Application number: 2020/93367	
What is the application for?:	Erection of single storey rear extension and raised deck
Address of the site or building:	Wellfield, 1, Upper Meadows, Upperthong, Holmfirth, HD9 3HR
Postcode:	HD9 3HR

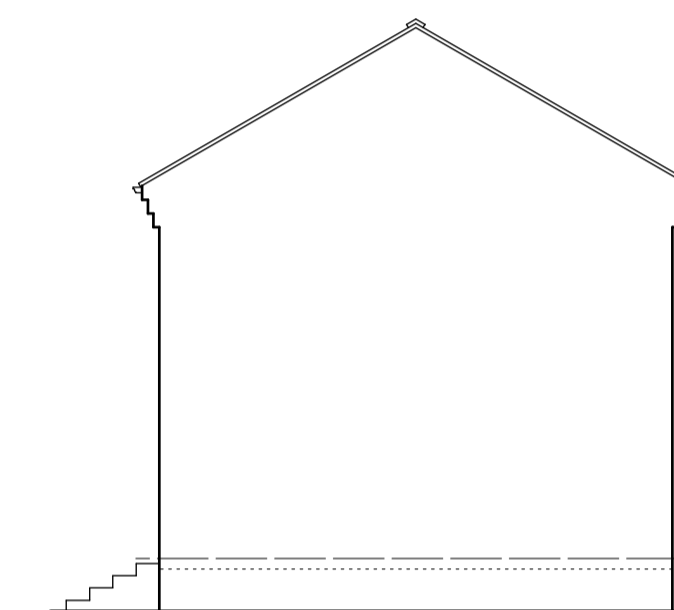
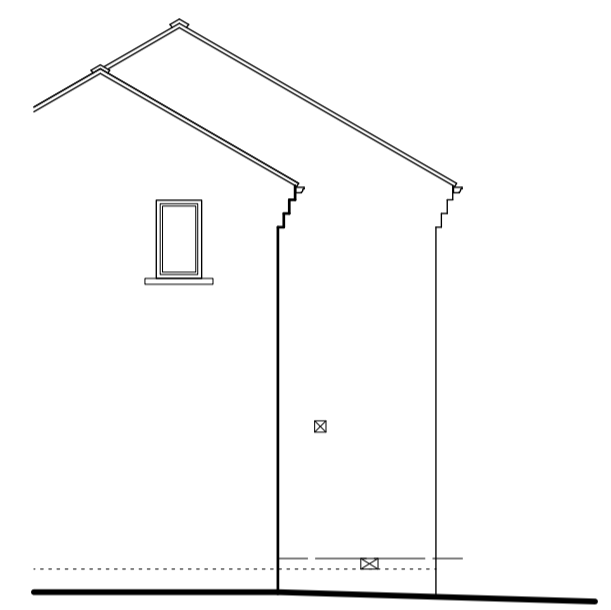
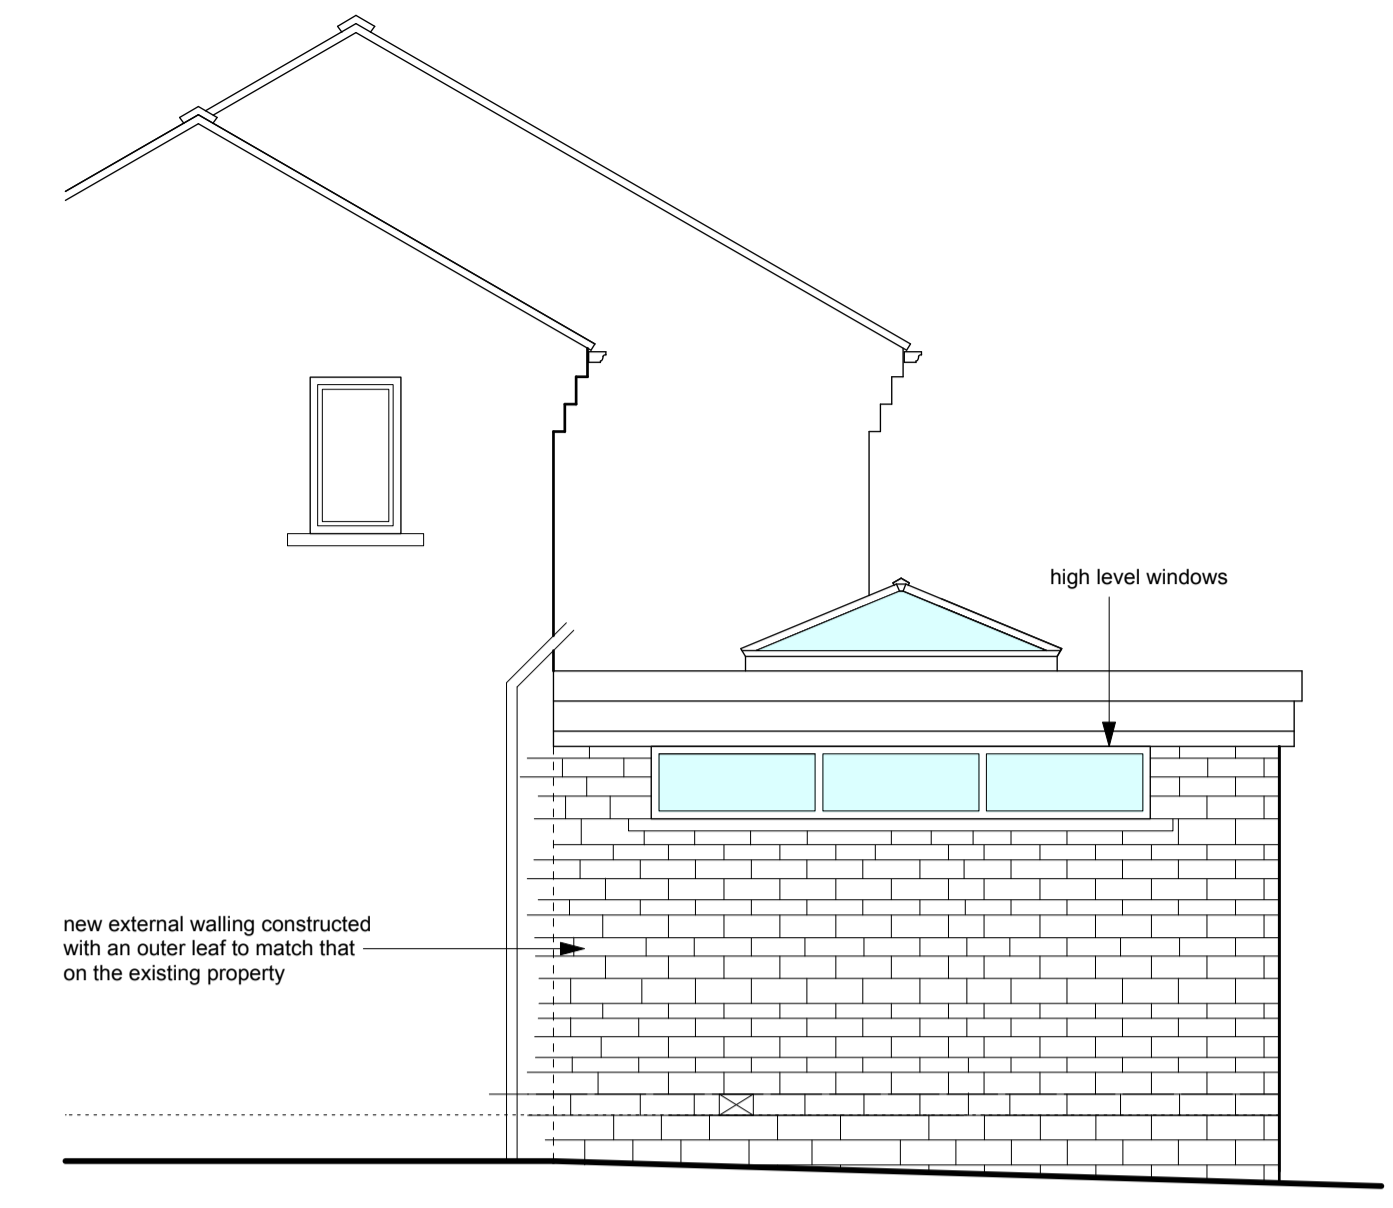
Type of comment: An objection
I am concerned that, due to the raised deck, we are going to be even more overlooked than we are now.
